COLORADO
Department of Transportation
Region 2
Traffic & Safety - Access Permits

83A/R-A/MP 27.60
Town of Monument/EPC

RE: PPR2433 - Monument Glamping 2

The Monument Glamping 2 Site Development Plan Letter of Intent received on 11/7/2024 and a Site Development Plan dated 8/14/2024 has been reviewed by CDOT Access Management. Our comments follow:

MICAH JEUB
GLAMPING II
SITE DEVELOPMENT PLAN

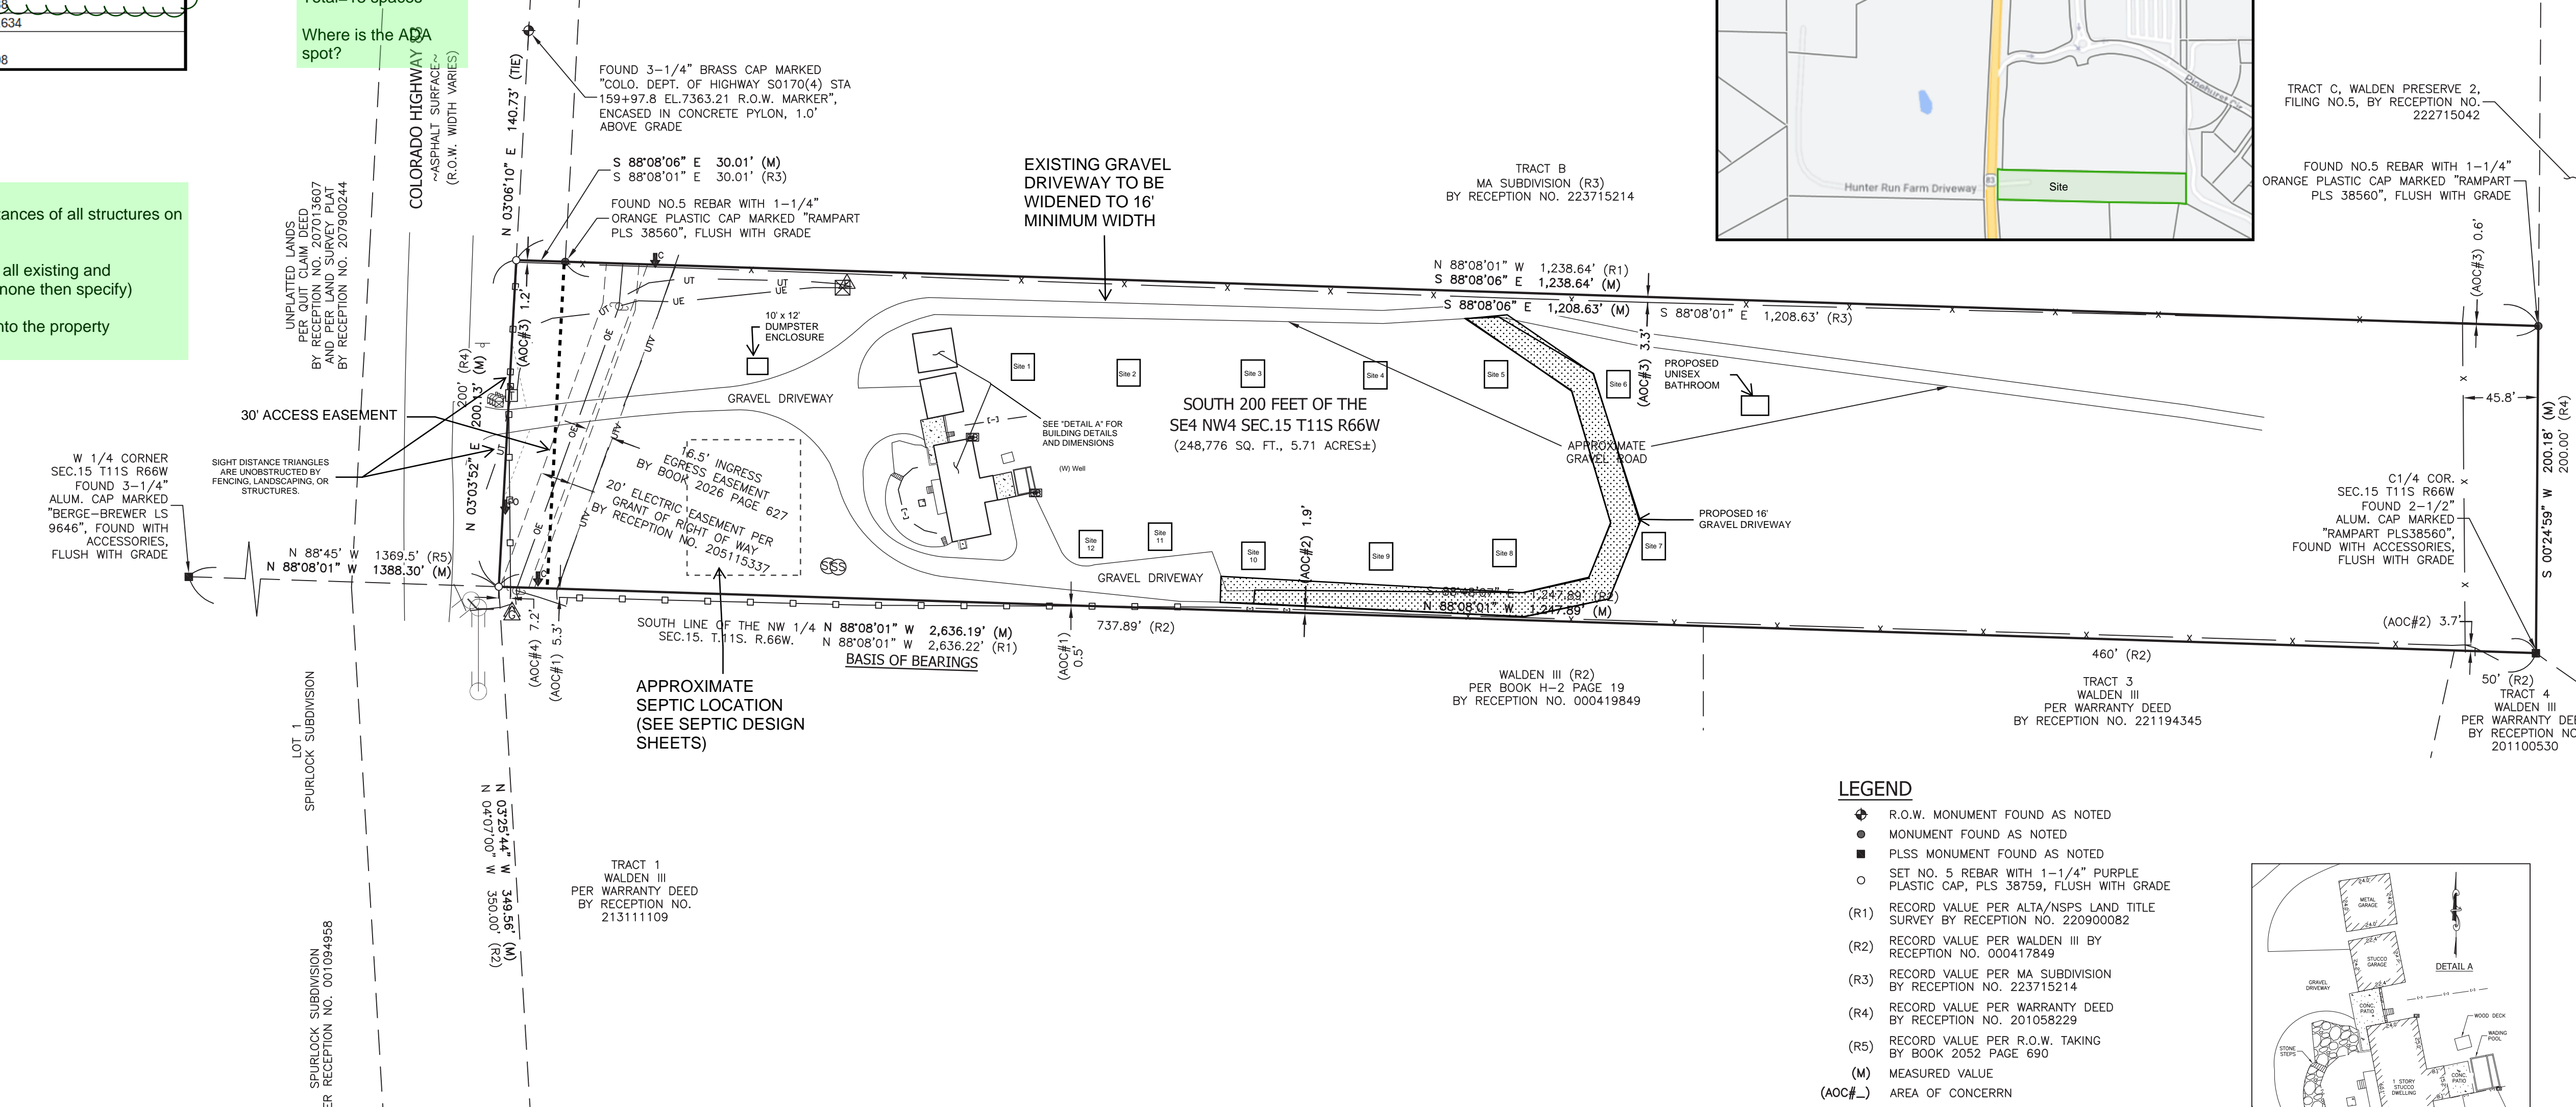
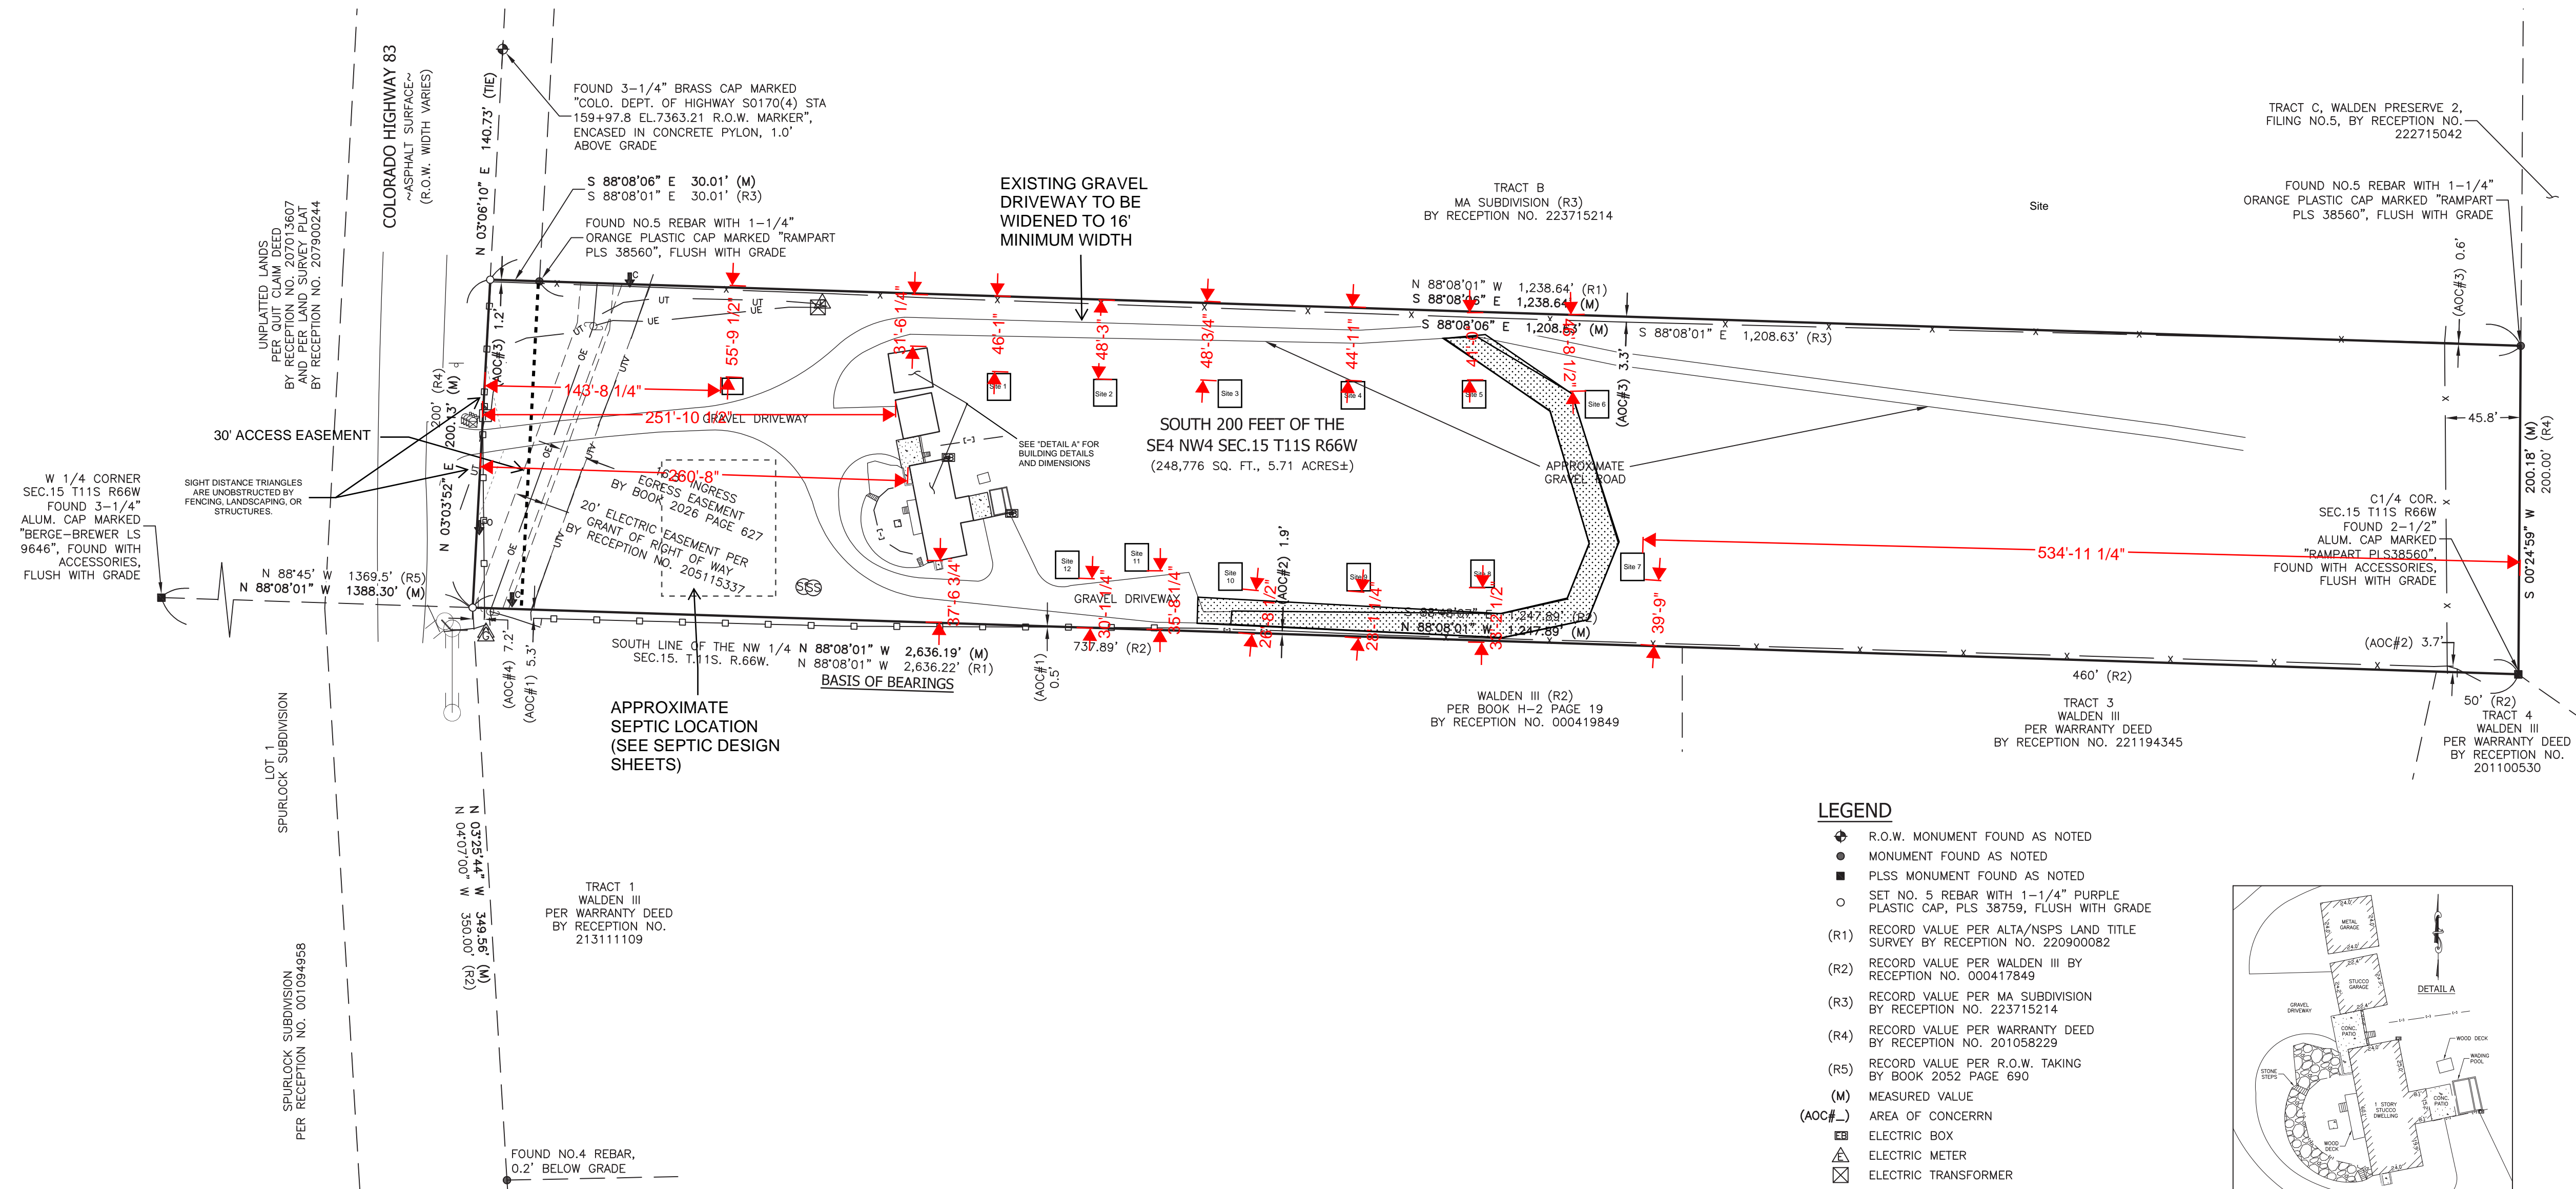
- Trip generation is acceptable.
- The intended access does not comply with the access control plan for State Highway 83A. The approved plan indicates cross lot access to Walden Way.

- A CDOT Access Permit (223018) was issued in May of 2023. The Notice to Proceed has not yet been issued.
- Access to the property is within the CO 83 Access Control Plan Intergovernmental Agreement among the City of Colorado Springs, El Paso County and the State of Colorado Department of Transportation.
- Dedication of a 30-foot access easement parallel with State Highway 83A shall be established and recorded with El Paso County before the Notice to Proceed will be issued
- In the future when an internal connectivity to/from Walden Way is developed the access will be closed.
